From: Anita Gardner <Anita.Gardner@arun.gov.uk>
Sent: 22 April 2021 16:53
To: Planning.Responses <Planning.Responses@arun.gov.uk>
Subject: FW: LU/50/21/PL : Proposal to place 20 Beach Huts at Sea Road Littlehampton.

From: Rod Brown [REDACTED]
Sent: 22 April 2021 15:59
To: Anita Gardner <Anita.Gardner@arun.gov.uk>
Subject: Re: LU/50/21/PL : Proposal to place 20 Beach Huts at Sea Road Littlehampton.

Floor Plan & Elevations. Scale 1:50@ A3
Arun District Council Beach Hut Application

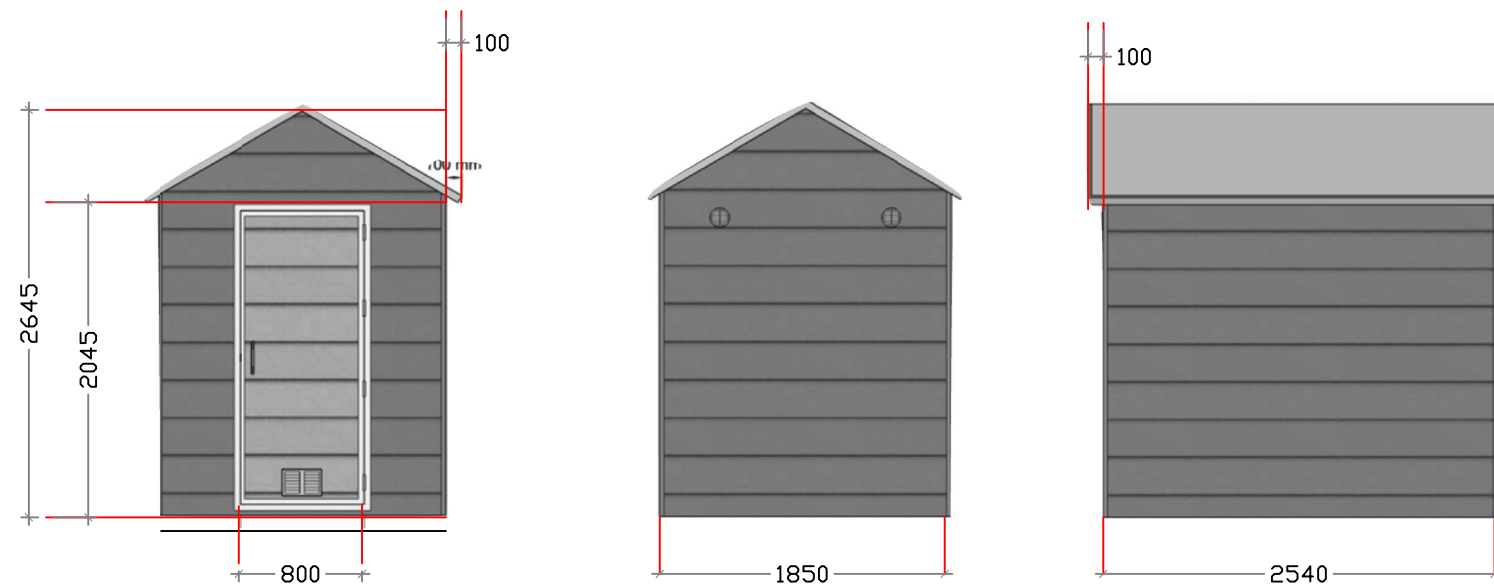
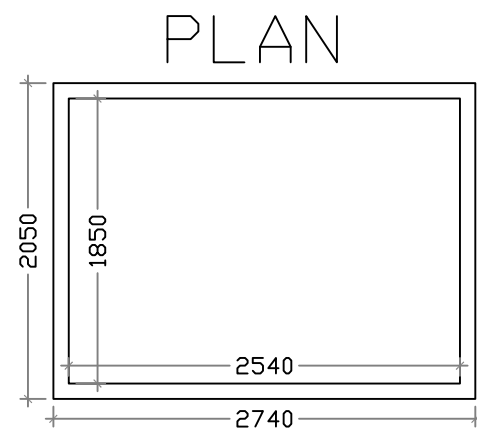
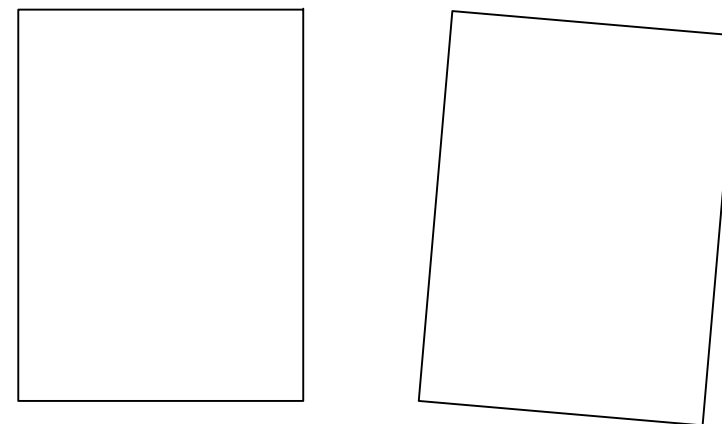
Another issue that I noticed on the Ocella web is the absence of Street View elevations showing the grouping of the huts. A single hut is shown - that is hardly sufficient to convey the effect of this proposal which deals with about 400 metres of strategic seafront! This is a matter of Town Planning rather than a single garden shed.
